# MASTER DRAINAGE REPORT

38 ACRE AND 45 ACRE TRACTS ALONG IRVING BLVD.

January 6, 1994

**Master Drainage Report for 38 Acre and 45 Acre Tracts  
along Irving Blvd.  
prepared for Argus Development  
by Community Sciences Corp. (CSC)  
November, 1993.**

PLATE #1 COMPOSITE DRAINAGE PLAN		community sciences corporation	SHEET OF
DATE 11/93 SCALE 1" = 500' DESIGNED DRAWN JOB NO.	LAND PLANNING P.O. Box 1328 Corrales, N.M. 87108

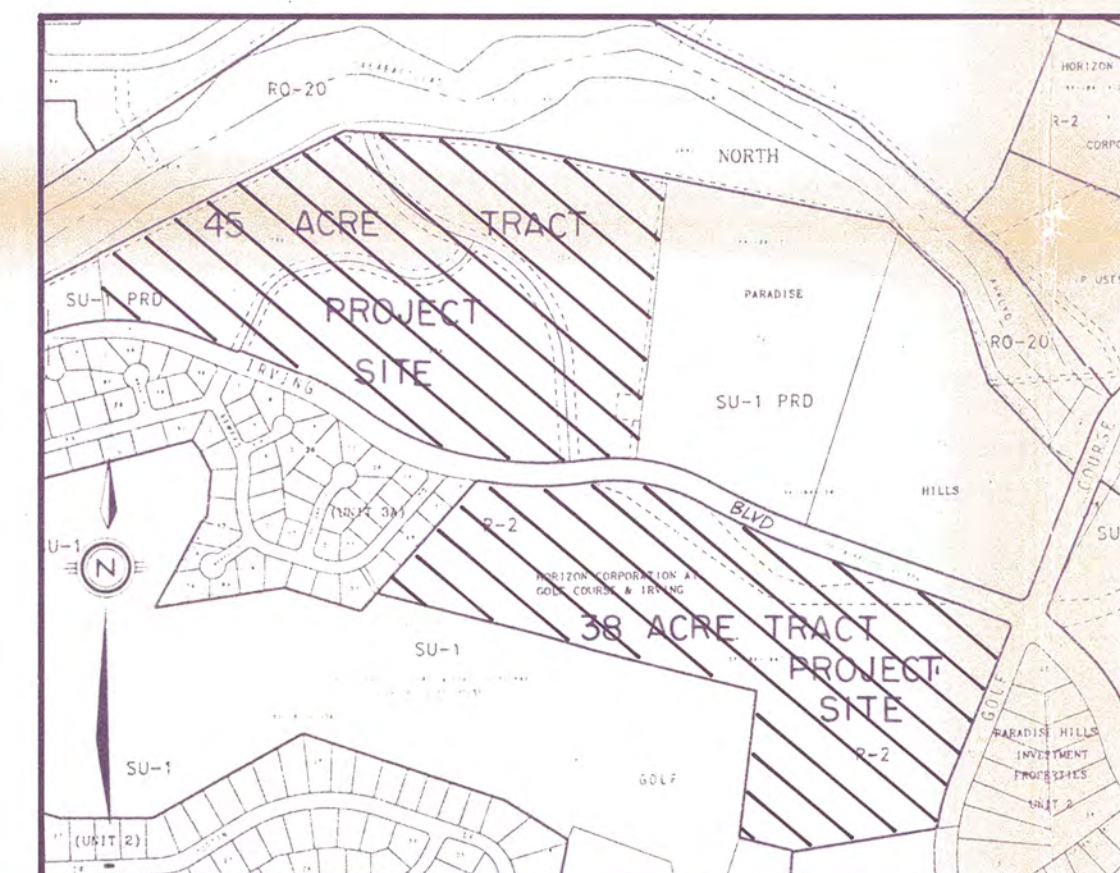
The AHYMO subbasin map has SLA Calabacillas cross-sections marked. See my remarks regarding sediment transport.

38 AC. TRACT A
PROPOSED DEVELOPMENT PLAN

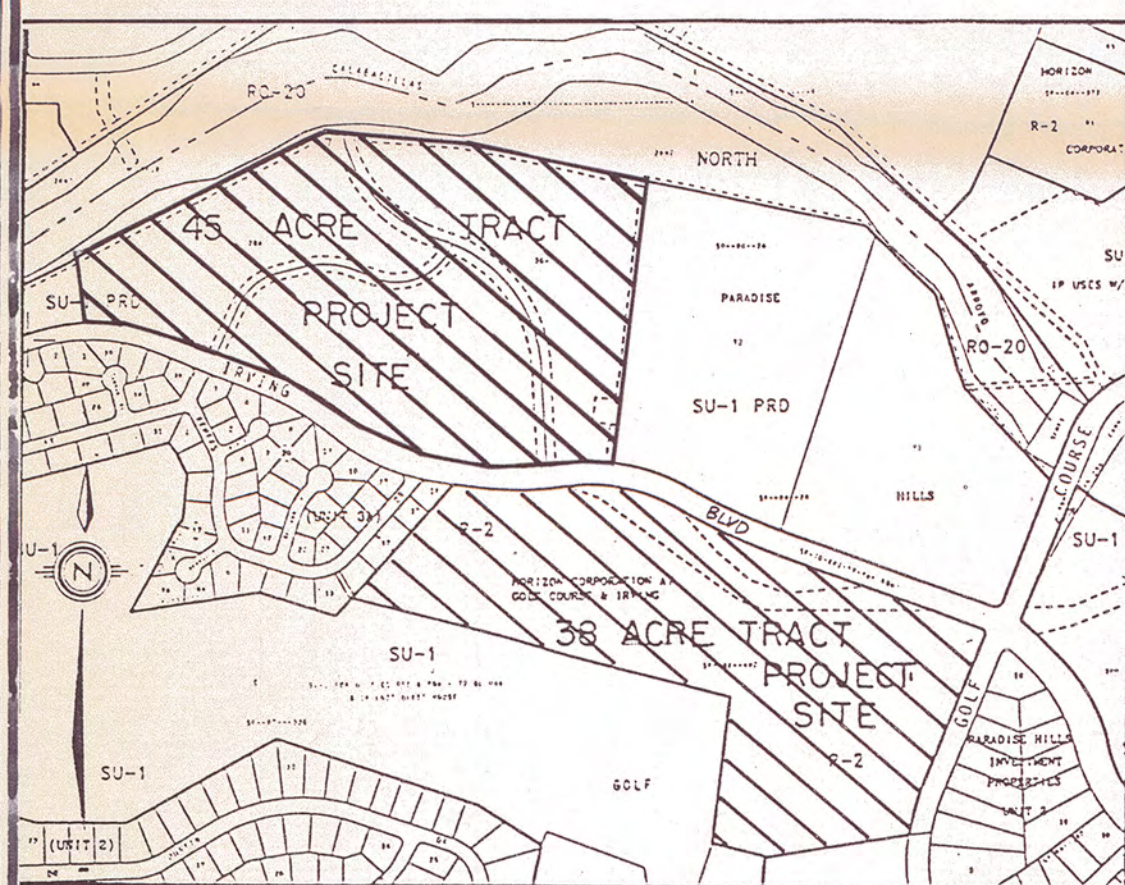
Item 4 of the 8/3/93 memo fails to acknowledge an easement from the golf course to Irving. Plate 2 shows direct grade into the tract, but no provision for conveyance. Does the easement serve an historic or potential purpose or has the golf course eliminated the need?
